JN 20046

Subject: **Review of Plans and Minimal Risk Statements** - Proposed Residence
Lot 2 – 5214 Forrest Avenue Southeast, Mercer Island, Washington

Plans: **Sturman Architects** – Sheets A1.0 through A6.0, Dated December 2, 2022.
Longitude 120 – Sheets S-0 through SD-3, Dated November 1, 2022.

FOUNDATION PLAN
SHEET S-2

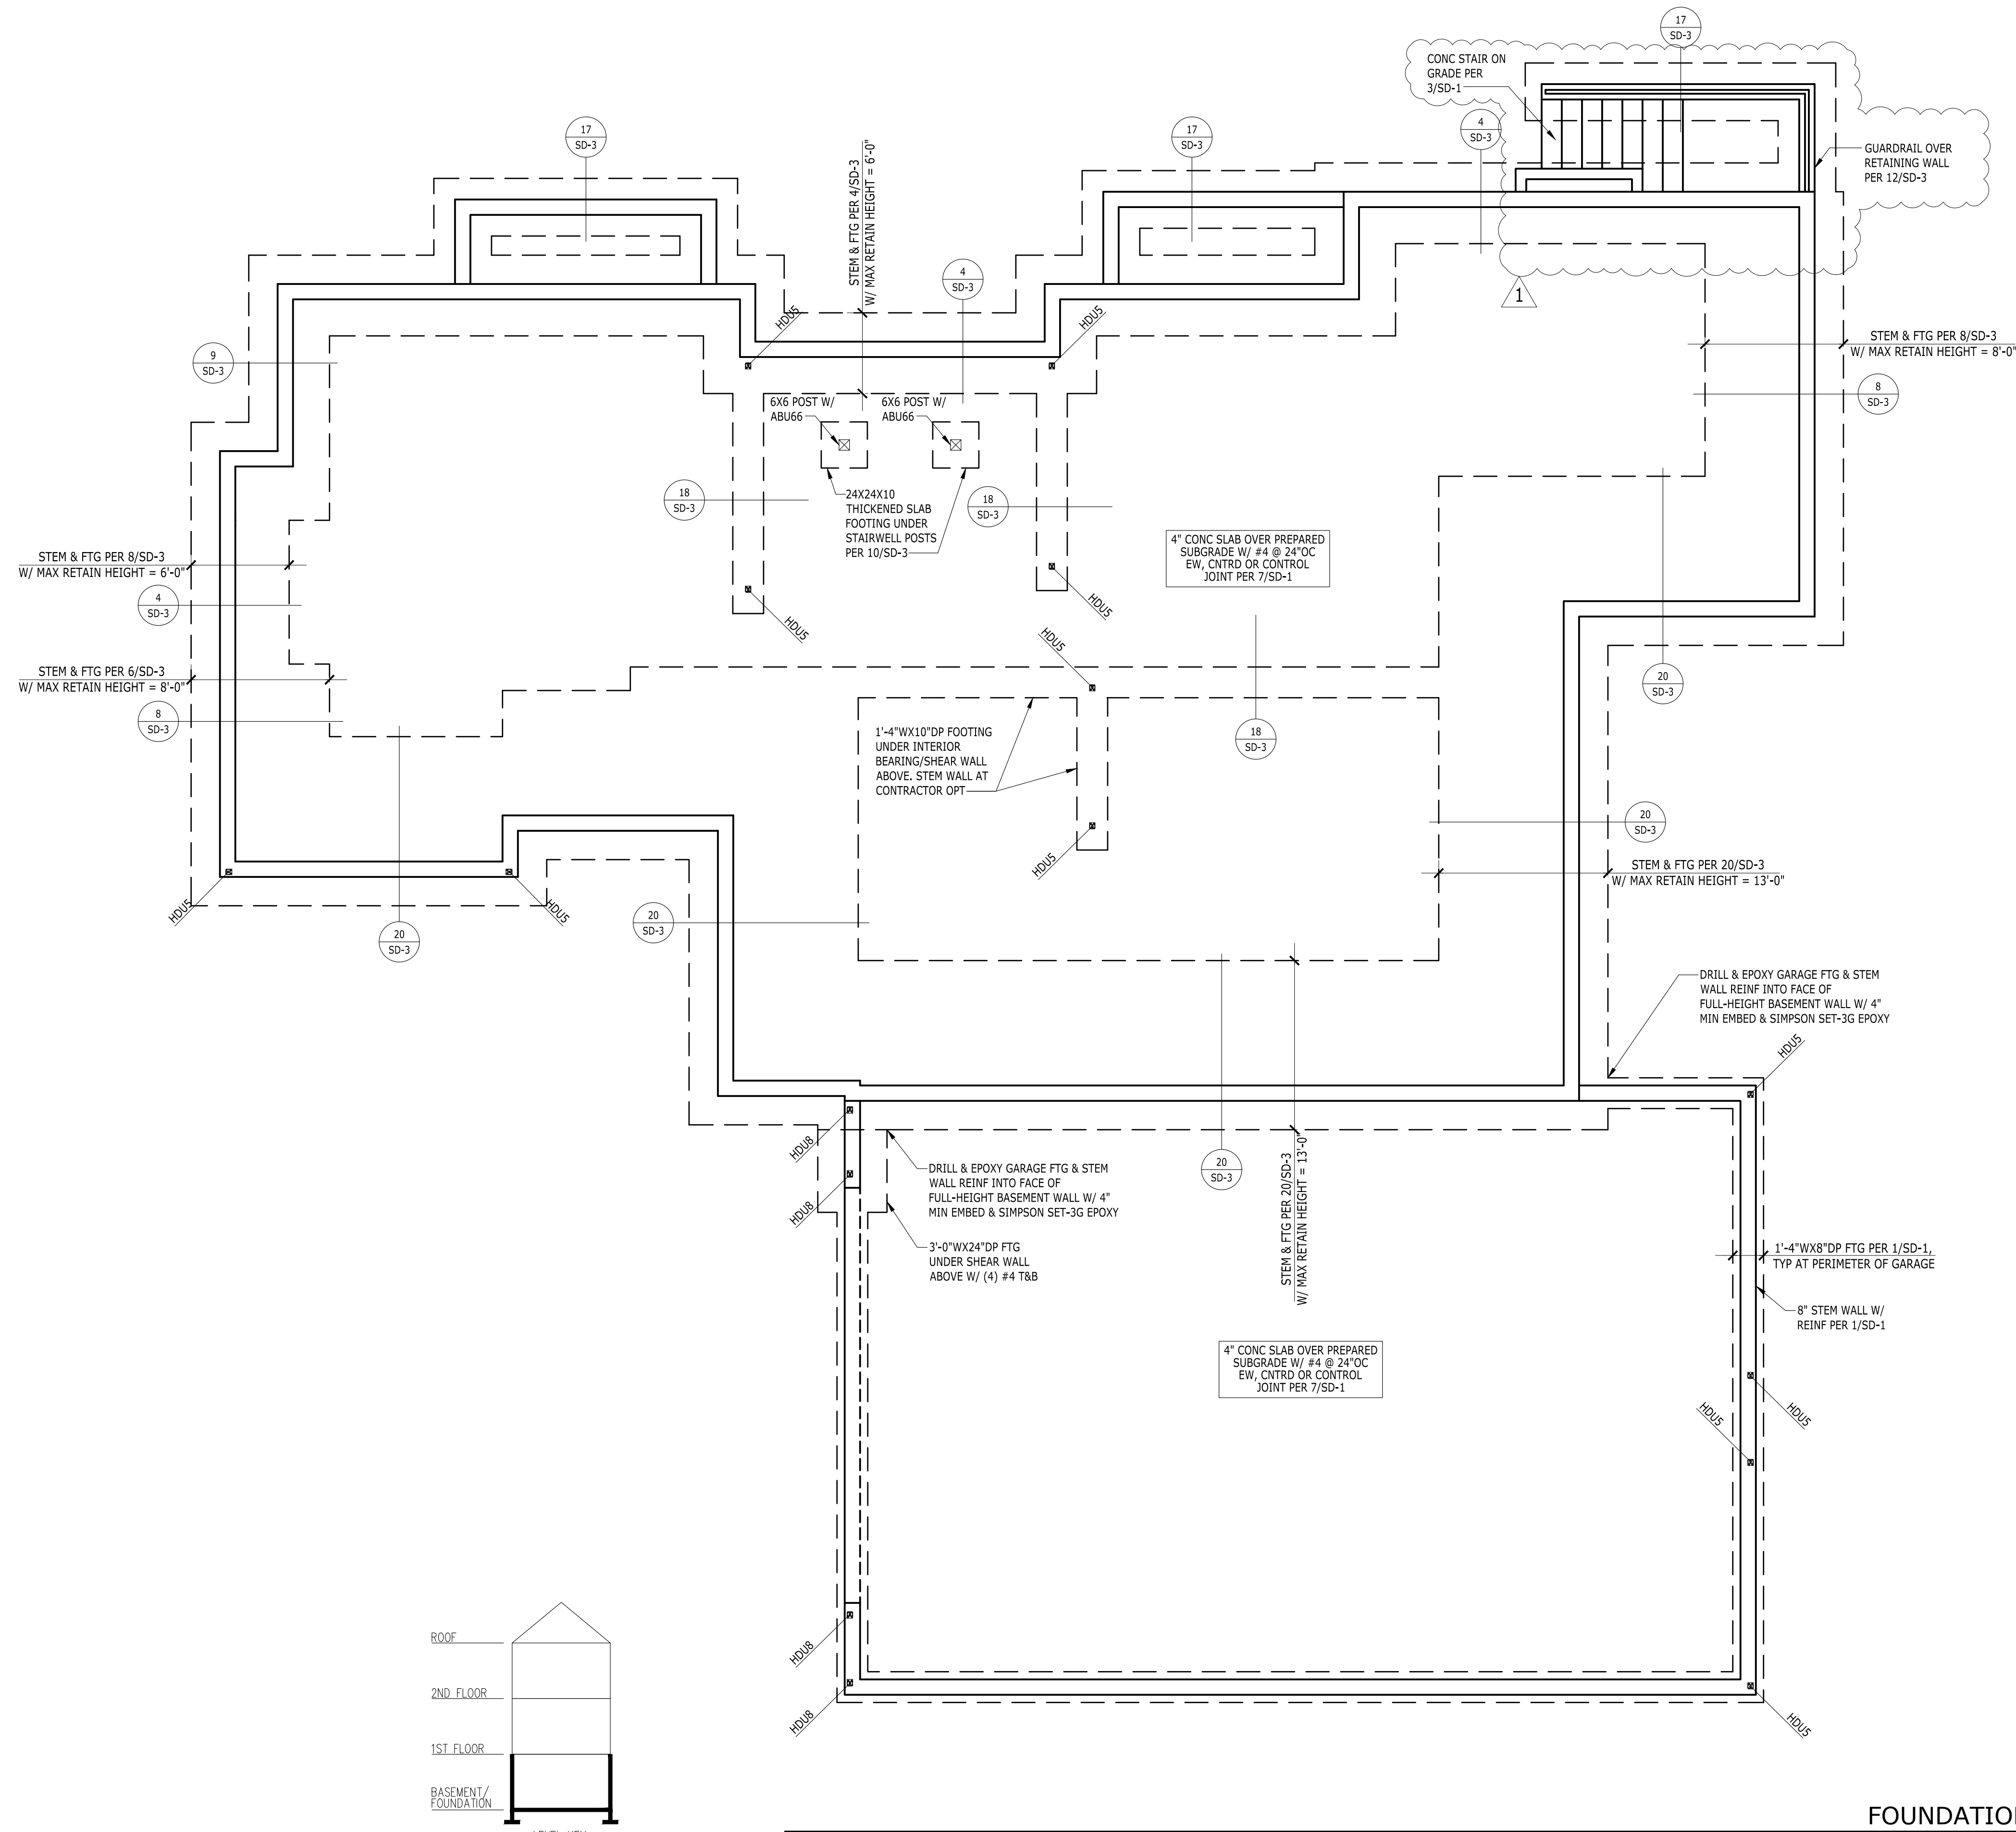
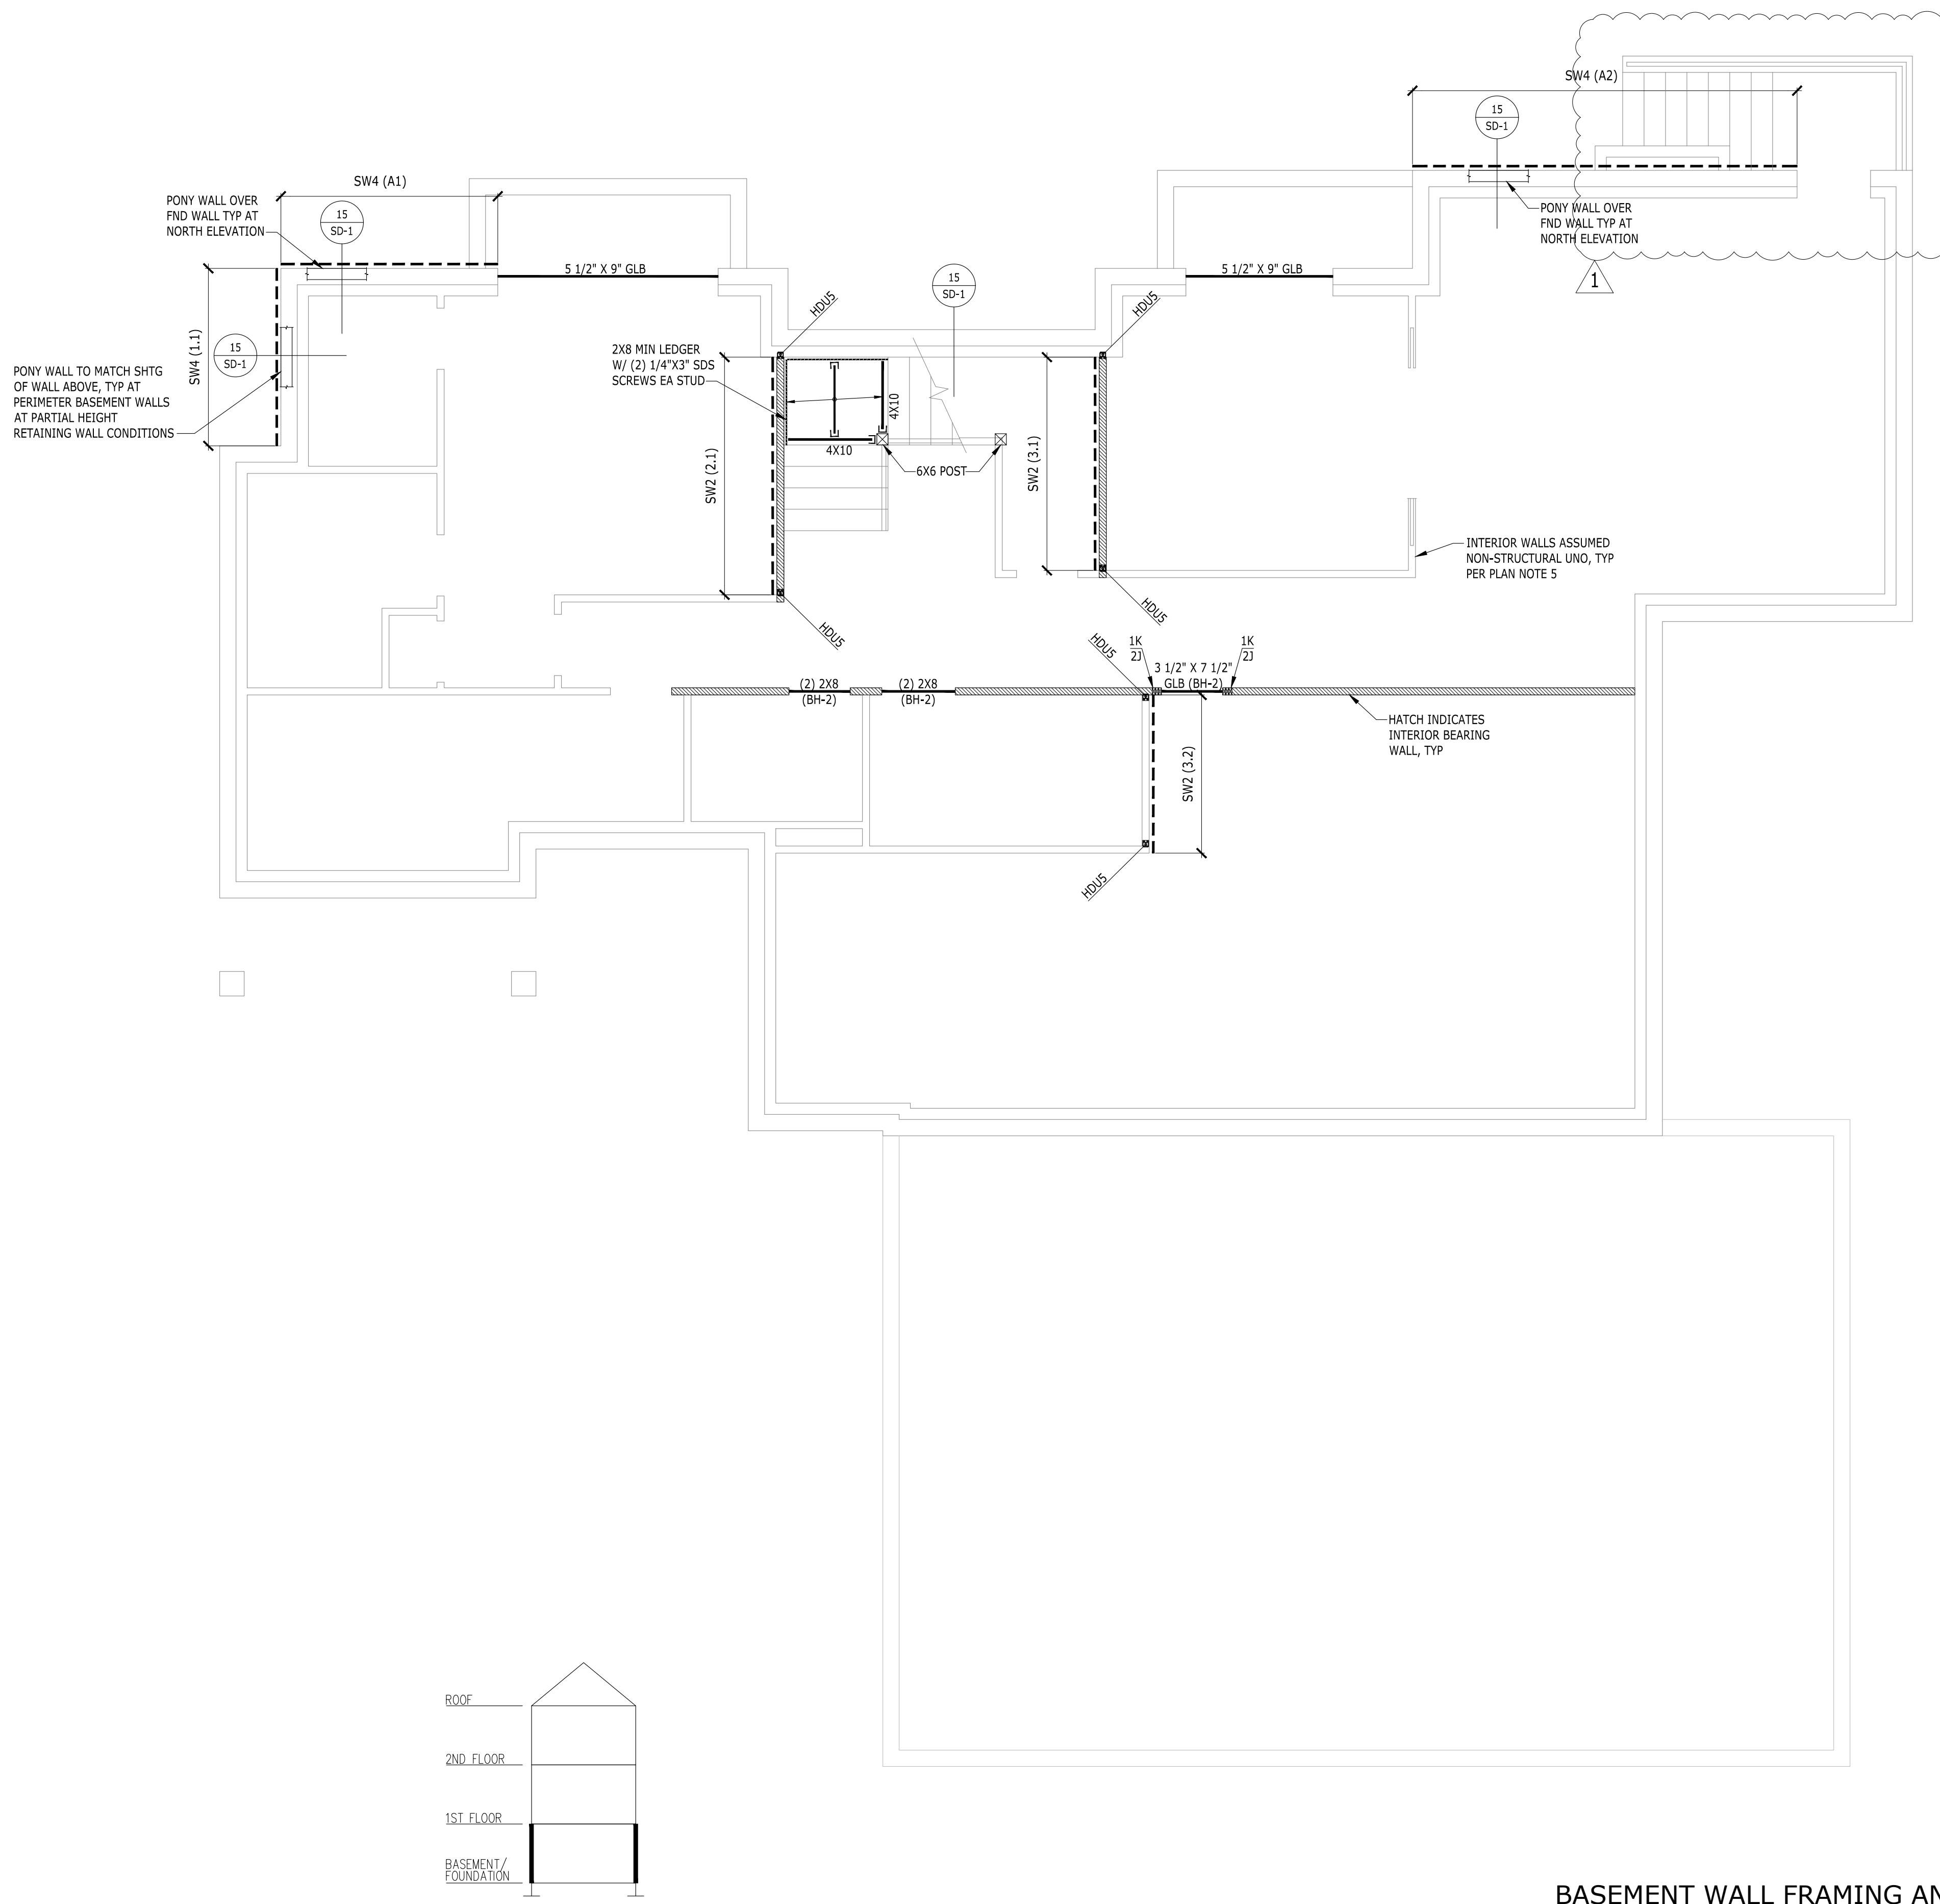
- As is obvious from the plans, temporary excavations from the neighboring lot to the south (Lot 1 of the development) will be necessary to construct the residence foundations.
- The column pad footings shown on the eastern end of the overhang above the eastern patio will need to be dug down to the medium-dense native soils located approximately 5 to 10 feet below the existing grades. Our engineers should be called to the site to evaluate these subgrades. These footings could also be set at or near the basement elevation and extended up to grade with sonotubes.
